Environmental Health Consultation Response			Officer	Hannah Kent
Detail: Variation of Condition 9 (External Lighting) of planning application 3			Flare SRU:	048151
Address:	27 Humber Street Longridge Preston Lancashire PR3 3WD			 <p>Ribble Valley Borough Council</p> <p><a href="http://www.ribblevalley.gov.uk">www.ribblevalley.gov.uk</a></p>
Application Ref:	3/2022/0596	Case Officer:	Mr Ben Taylor	
Response Ref:	3/2022/0596/ENV/01	Issue Date:	18 July 2022

27 Humber Street Longridge
External Lighting

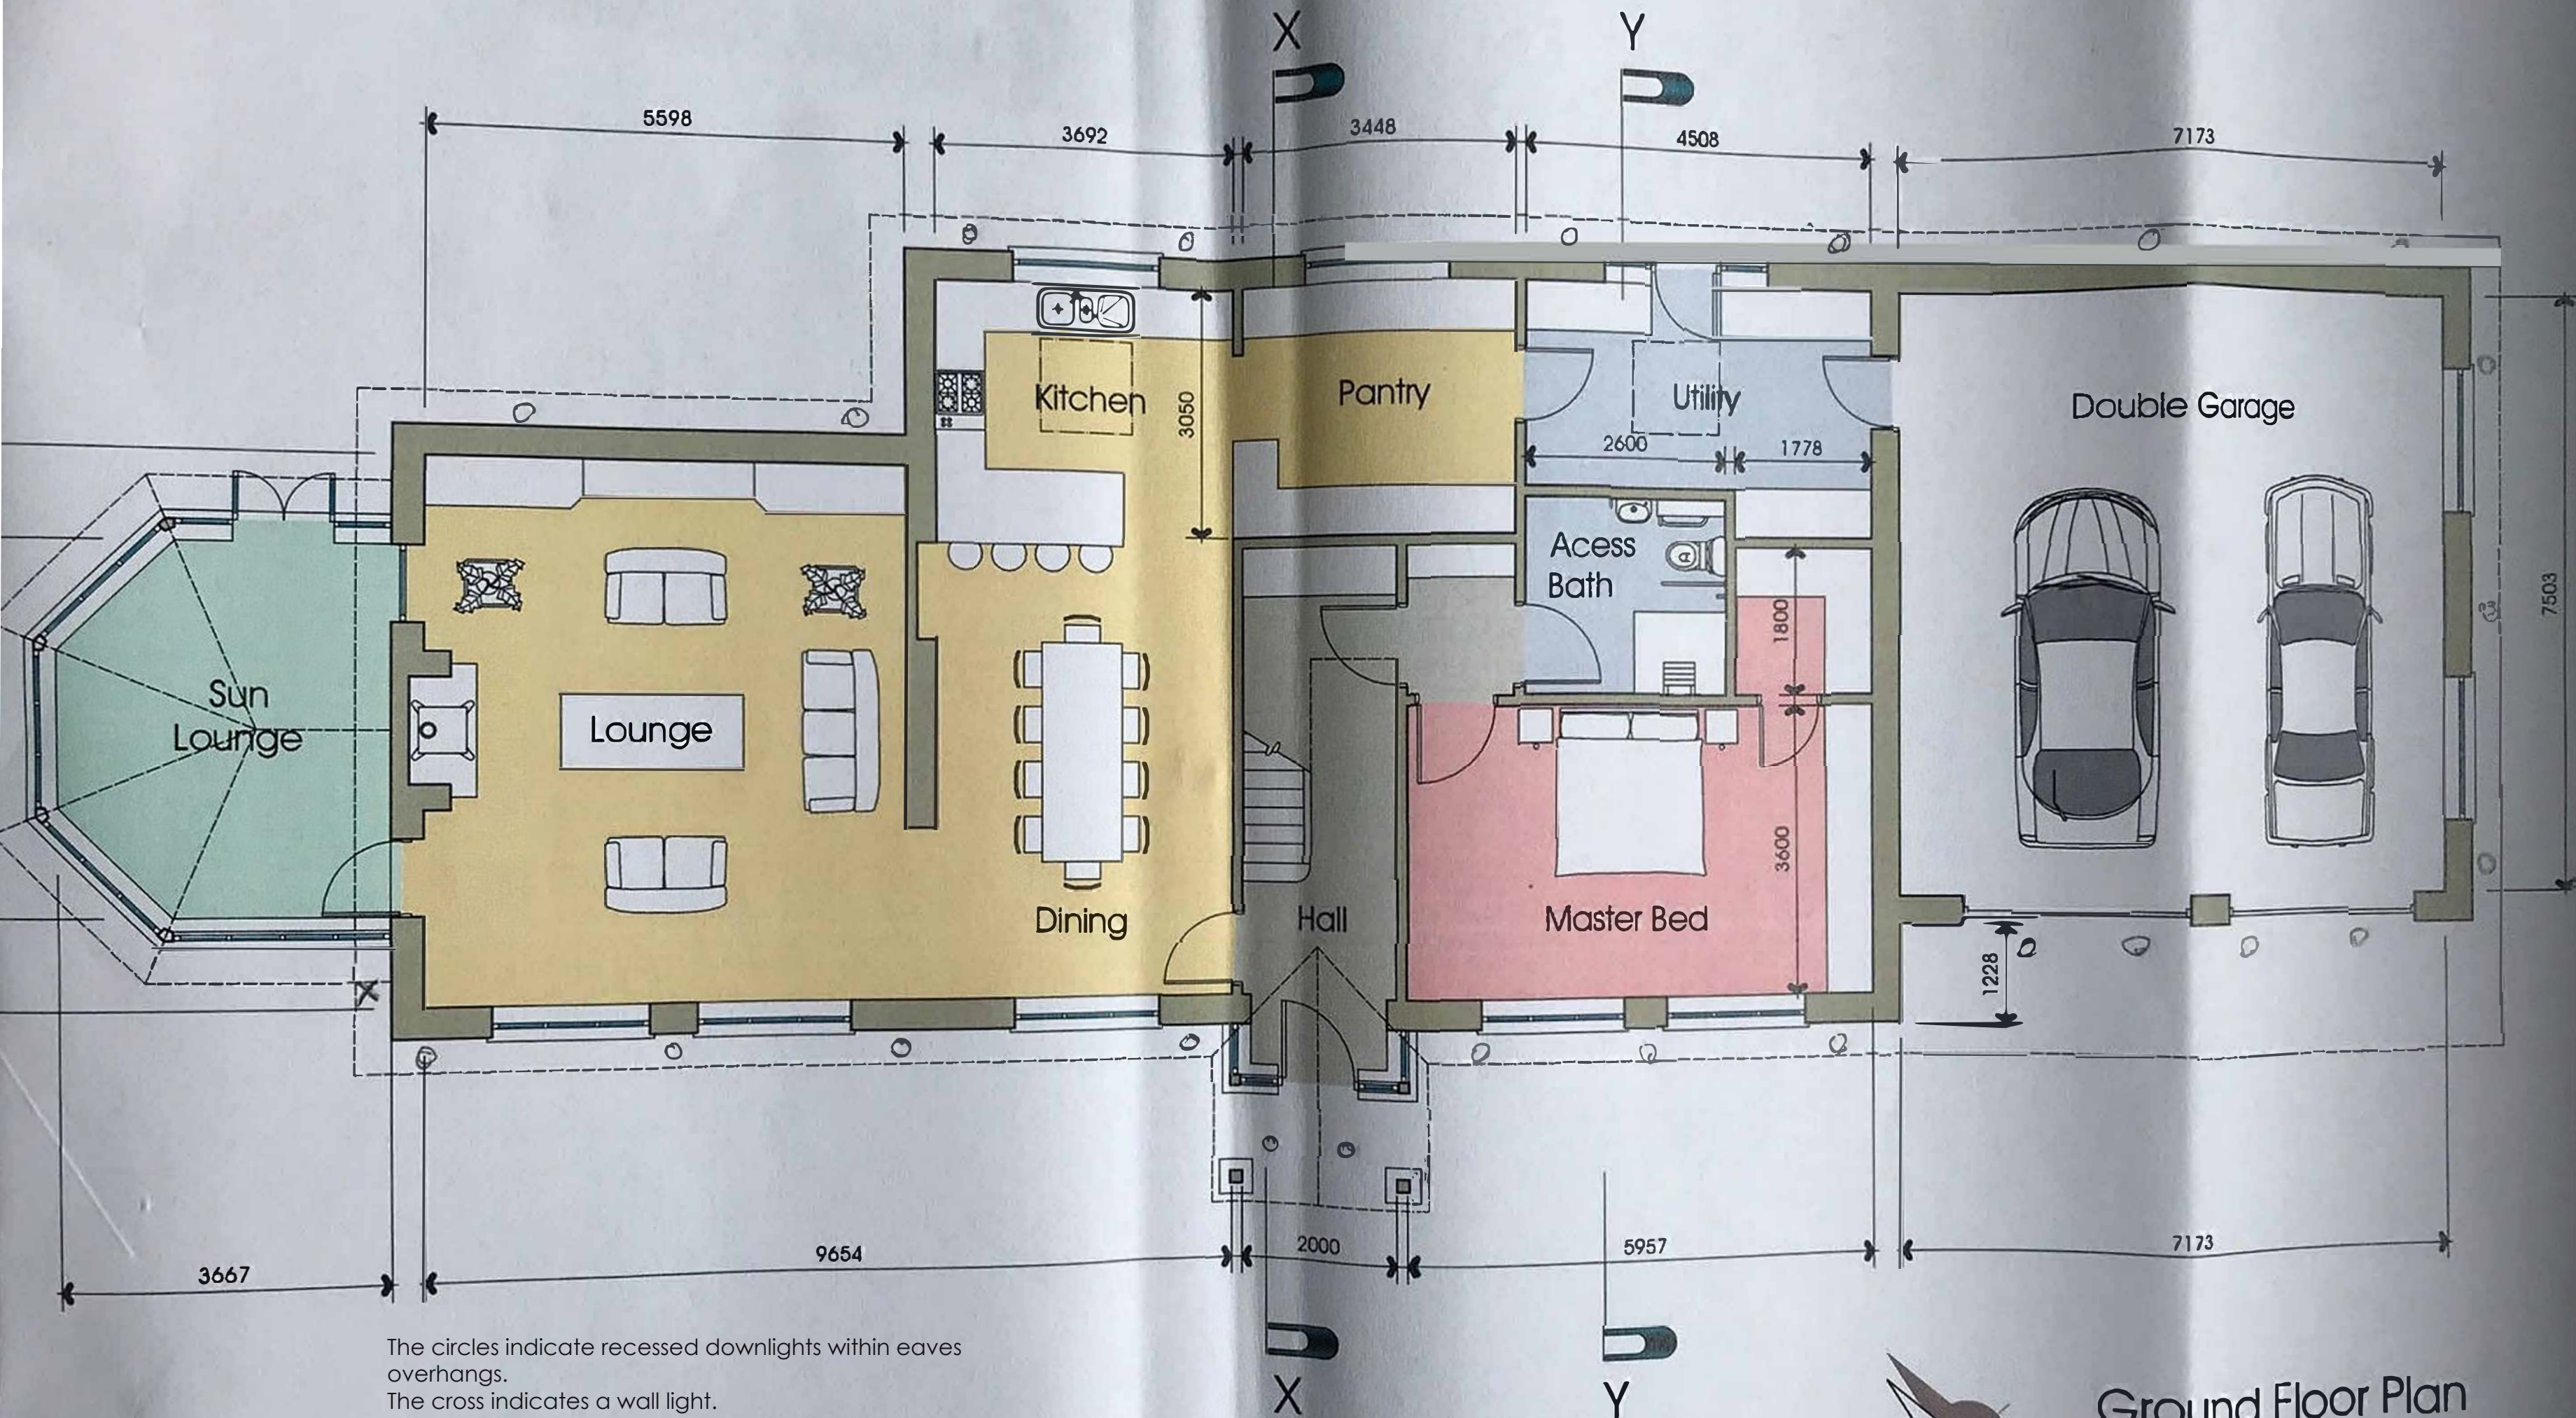
General Comments/Observations	
1.1	The property is in close proximity to a number of residential dwellings, some of whom have identified that the lighting is a nuisance illuminating the façade of the building unnecessarily.

1.2	The images supplied with the planning variation application identify more than 20 external lights which appears excessive.
1.3	The excessive use of lighting increases the risk of impacting biodiversity whilst detracting from the natural and local environment and increasing greenhouse gas emissions contrary to chapters 14 and 15 of the National Planning Policy Framework.
Suggestions/Mitigation

2.1	Reduce the number of lights to an absolute minimum.
Conclusions/Suggested Conditions	
2.2	The above observations have been provided on the basis of the level of information submitted and the comments contained within this response represent officer opinion only, at the time of writing, without prejudice.

2.3	I would therefore suggest that the application be refused and that the original lighting condition is retained.
<p><b>Reason:</b> To safeguard the amenities of the occupiers of nearby properties and promote sustainable development in accordance with Chapters 2, 14 and 15 of the NPPF.</p>	
	<p><b>Officer:</b></p> <p><b>Hannah Kent</b></p>
